One Earth Solar Farm

**Draft Statement of Common Ground with Nottinghamshire
County Council**

EN010159/APP/8.3.2

October 2025

## A.6.5 Figures

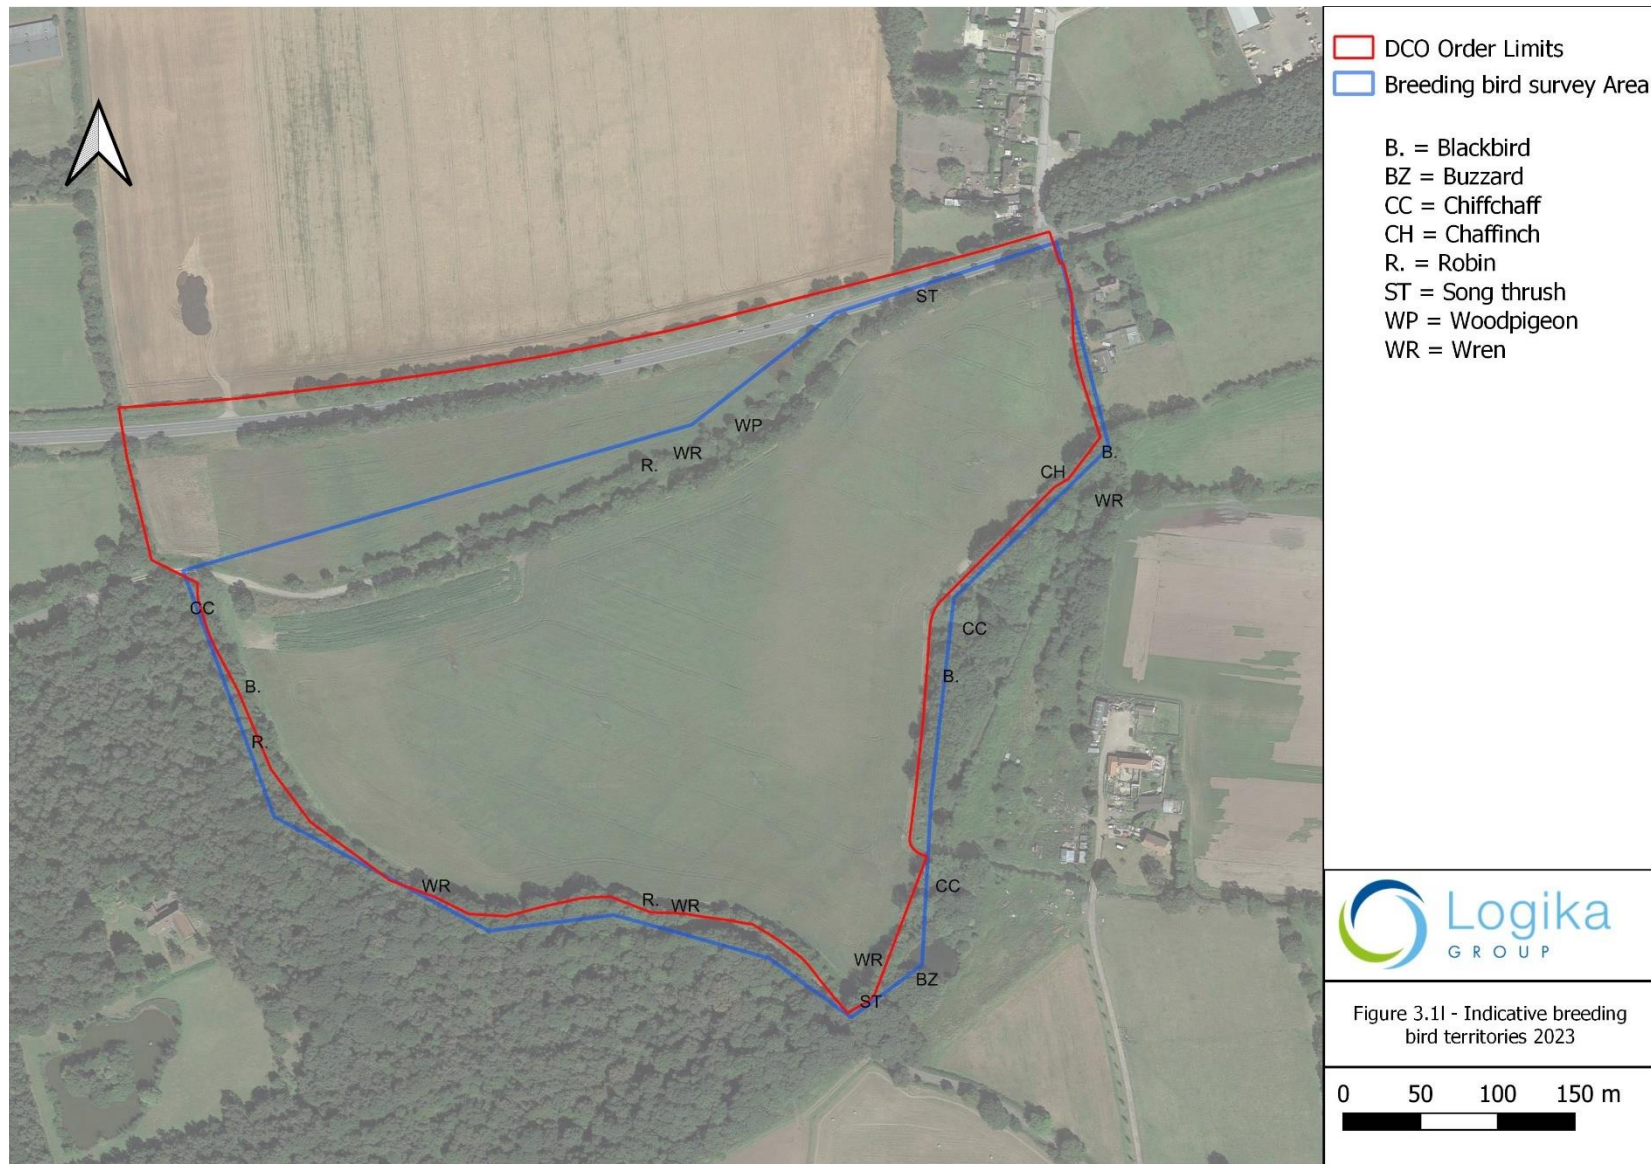
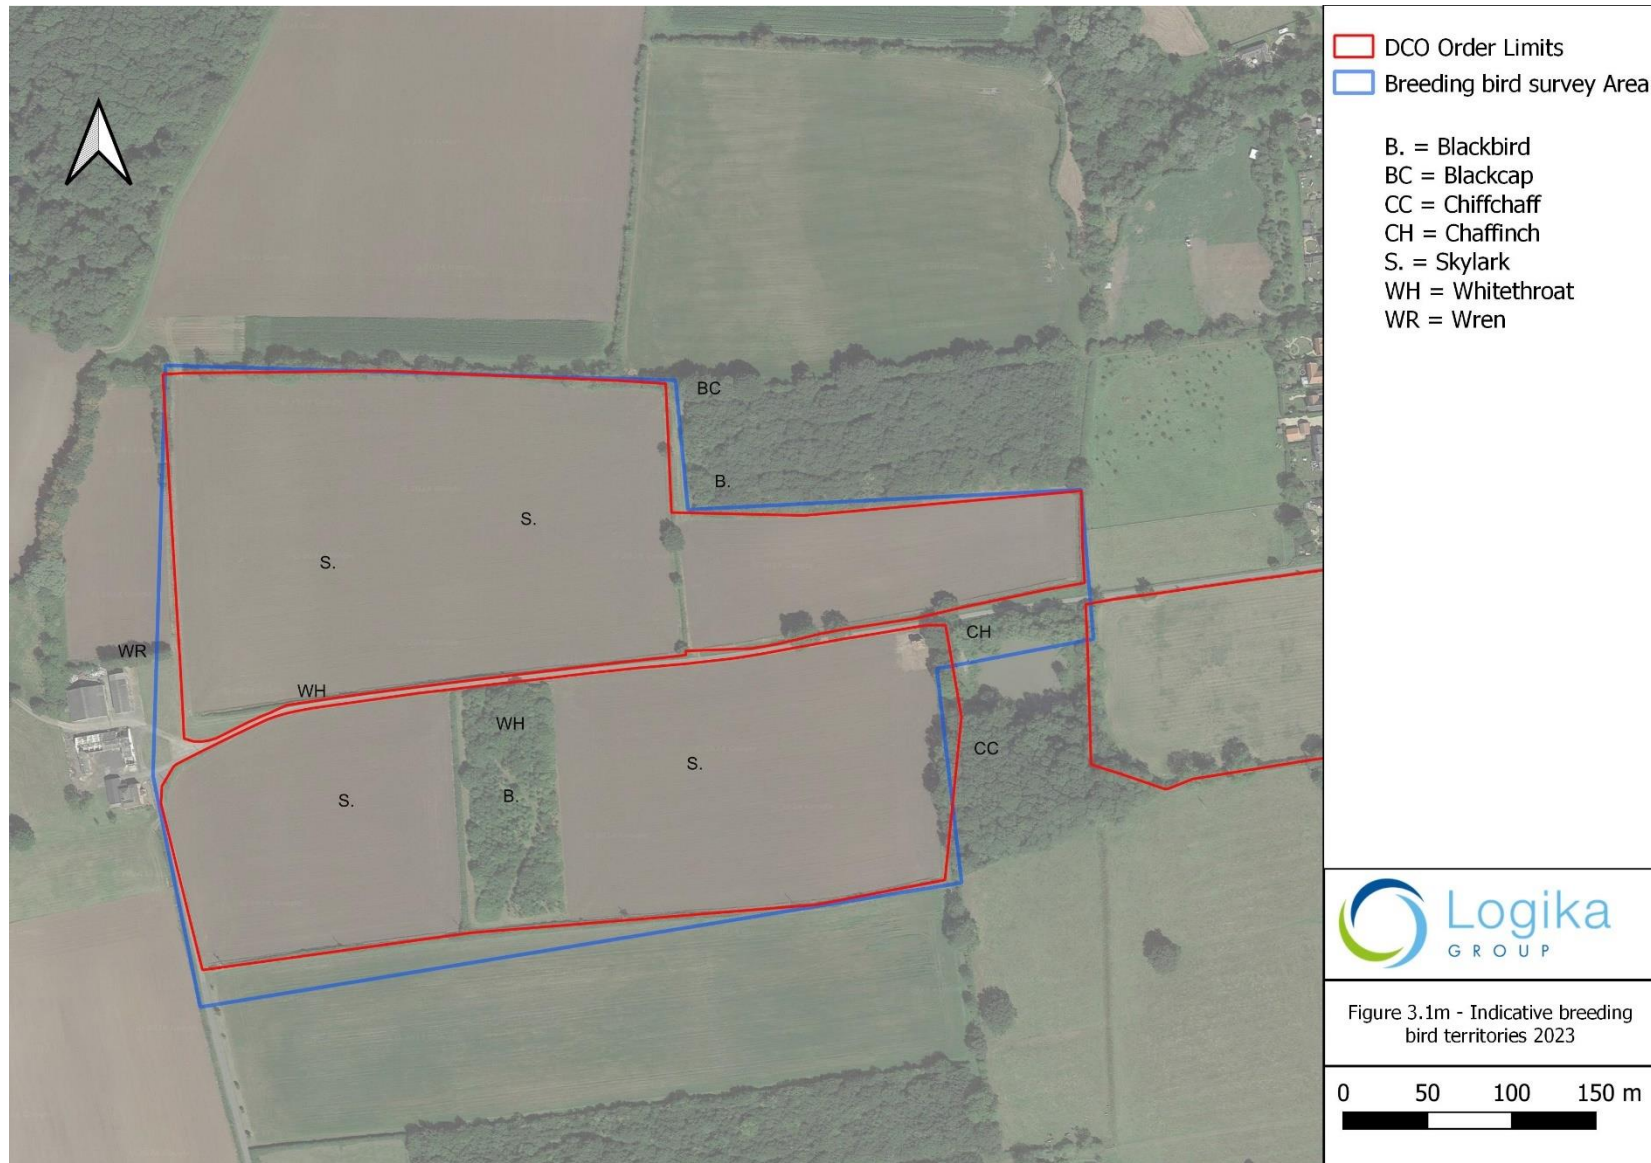
05-04	Survey of Skylarks	Impacts on ground nesting birds, particularly Skylarks, seem to be of greatest concern, but it does not appear that an attempt has been made to estimate how many Skylark territories there will be post-development,	With regards skylark, the mitigation proposed is considered appropriate to provide breeding opportunities to all pairs that may be displaced from the solar array areas.	Under discussion

with mitigation. Furthermore, with regards to para 6.10.92 of the Biodiversity Chapter, further detail is needed of the extrapolation of Skylark territories has been carried out, given only a quarter of the site was surveyed and the extrapolation from 66 pairs to 115 pairs suggests that half the Limit Order is unsuitable for Skylarks, which seems unlikely. In summary, the approach to breeding birds represents a significant area of concern.	An updated extrapolation for skylark was provided at Deadline 1 in Chapter 6 Biodiversity [REP1-023] (see paragraph 6.10.105). Yellow wagtail are considered in the 'Other breeding bird section of Chapter 6 Biodiversity [REP1-023]. This species has been shown to occur within solar farms and should benefit from measures such as the provision of SuDS, temporary ponds and scrapes (see C21 in Table 6.6 Chapter 6 Biodiversity [REP1-023]), and positive management of ditches (see C22 in Table 6.6 Chapter 6 Biodiversity [REP1-023]) due to their feeding preferences.
